**SOUTH DERBYSHIRE DISTRICT COUNCIL’S COMMENTS ON
DIANE ABBOTT’S NOISE REPRESENTATION**

Oaklands Farm Solar Farm NSIP

PINS Reference: EN010122

EN010122 - Oaklands Farm Solar Park NSIP – SDDC’s Comments on Diane Abbott’s Noise Representation

Figure 4: Measured levels at Park Farm House

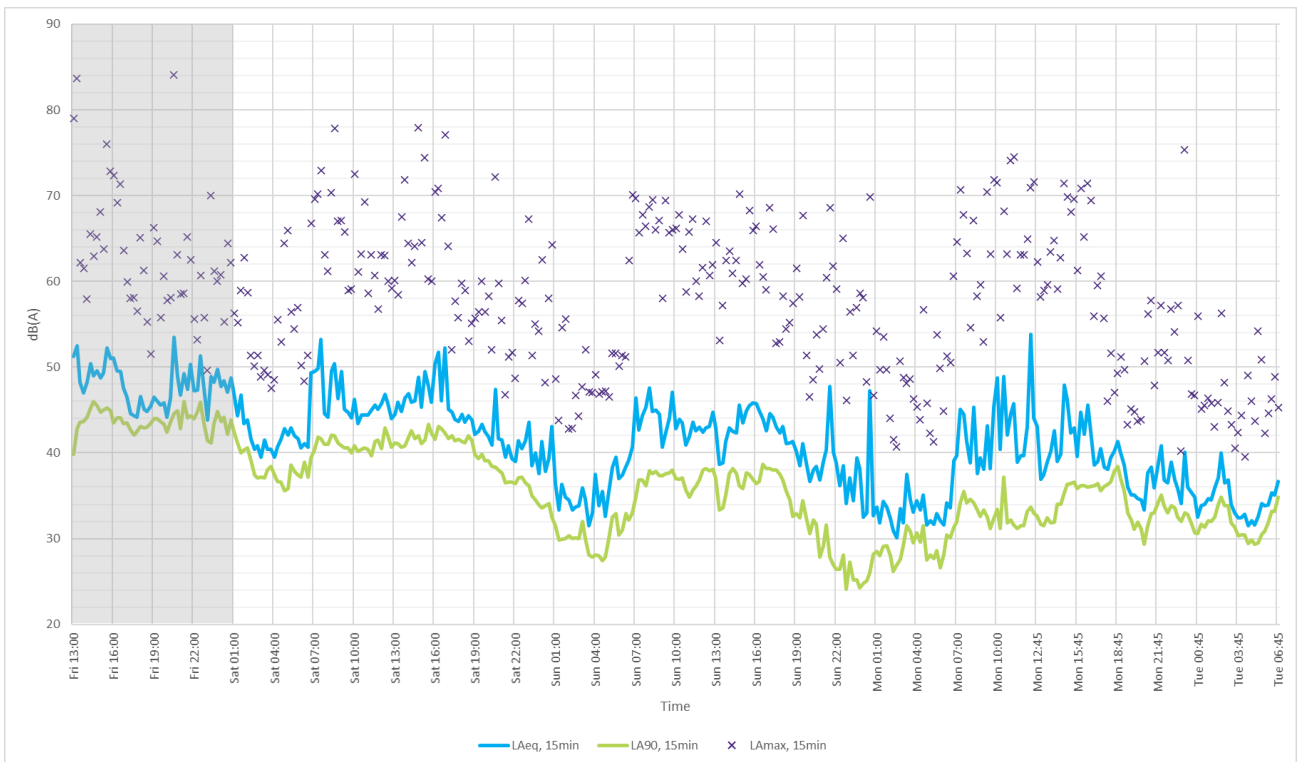
6.	<p>The long-term sound recording meter at Twin Oaks failed, therefore there is only limited short term data available for some of the closest properties to the development.</p>	<p>SDDC are satisfied that the monitoring is sufficient to characterise the existing noise climate, in terms of both duration and locations, given the nature of the noise under consideration.</p>

Plate 2: Illustration of typical storage inverter cabinet

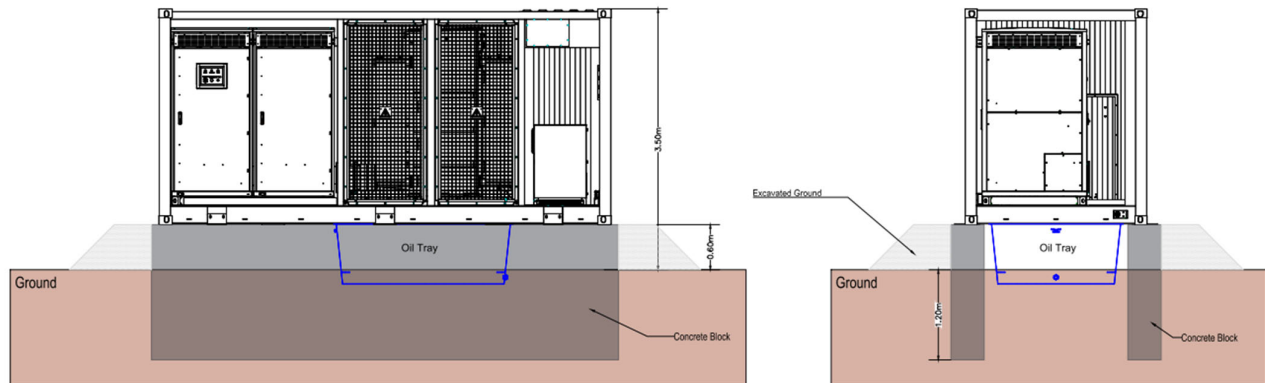
Item:	Diane Abbott’s Comment	SDDC Response:
12.	<p><u>Night-time noise predictions.</u></p> <p>In Section A11.3.4 (Appendix 11.3 Operational Noise Source Data) it is stated that the string inverter fans will run when the ambient temperature is above 20°C and solar output is above 70kW. The Applicants claim (without presenting evidence) that this is unlikely to occur before 7am and therefore the night-time noise predictions “assume” that the inverters only emit 62dB (rather than 84dB with fans running).</p> <p>Due to climate change, we are now seeing more tropical nighttime temperatures (exceeding 20°C) in the UK, and this trend will continue. As the sun rises as early as 5am in the summer, I believe it is quite likely that during warmer periods the cooling fans could be running well before 7am. This therefore needs to be factored into the night-time noise predictions. Could the Applicants provide more evidence regarding the likelihood of the inverter fans running in the early morning or late evening and / or resubmit noise predictions based on fan noise at nighttime.</p> <p>NB: Mallard Pass section 10.5.7 assumed the worst case; that fans would run at maximum power during all daylight hours:</p> <p>“This plant will mainly operate during the daytime, in which background noise levels tended to be more elevated; however, during the summer months, daylight periods may extend to early morning periods (05:00 to 07:00) and evening periods (18:00 to 23:00). Therefore, as a worst case, the plant noise from the Proposed Development has been considered against these quieter periods. Also, the plant has been assumed to operate at full duty (with its maximum level of noise emission) during this period.”</p>	<p>SDDC consider that there is a potential for the temperatures to exceed 20°C during noise sensitive hours, albeit it on very rare occasions. However, given that the Applicant has not considered this potential impact in detail, it would not be unreasonable for further assessment or controls to be provided. In the absence of any assessment of this impact, SDDC would suggest the applicant put measures in place to ensure that the system does not operate during noise sensitive hours in the event the ambient temperatures exceed 20°C.</p>

Plate 4: Noise data for 90MVA transformer

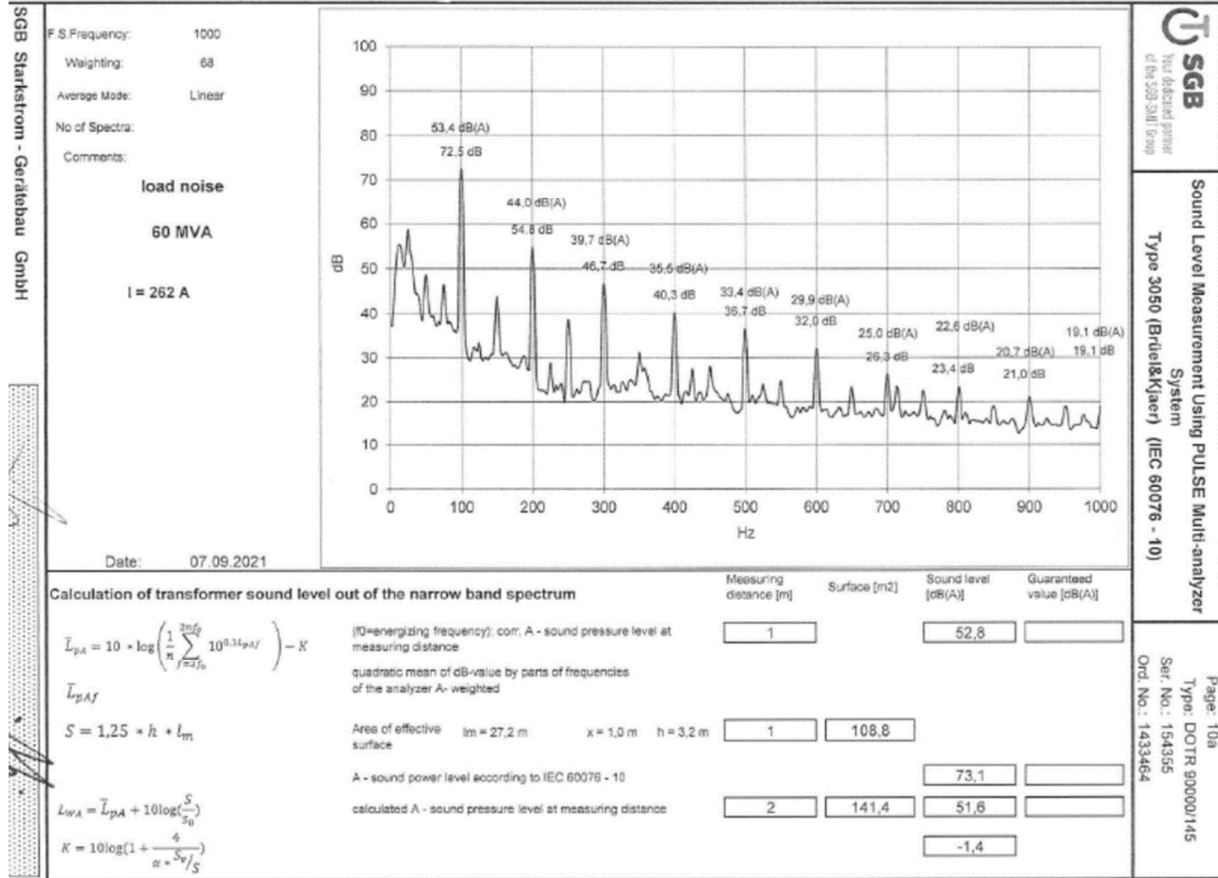
14.	<p>I am not satisfied with the response regarding low frequency noises as these are known to travel for considerable distances (several km) with minimal attenuation. The Applicant fails to consider this fact when they state:</p> <p>“The most likely source of low frequency sound would be from the substation plant which has been located over 500m from residential properties and is not assessed to result in a significant noise impact.”</p>	<p>Low frequency noise can be a significant issue in regards to the types of installations commonly associated with solar farms. However, this can be suitably controlled through the submission of the operational noise assessment to the Local Planning Authority prior to the start of works.</p>
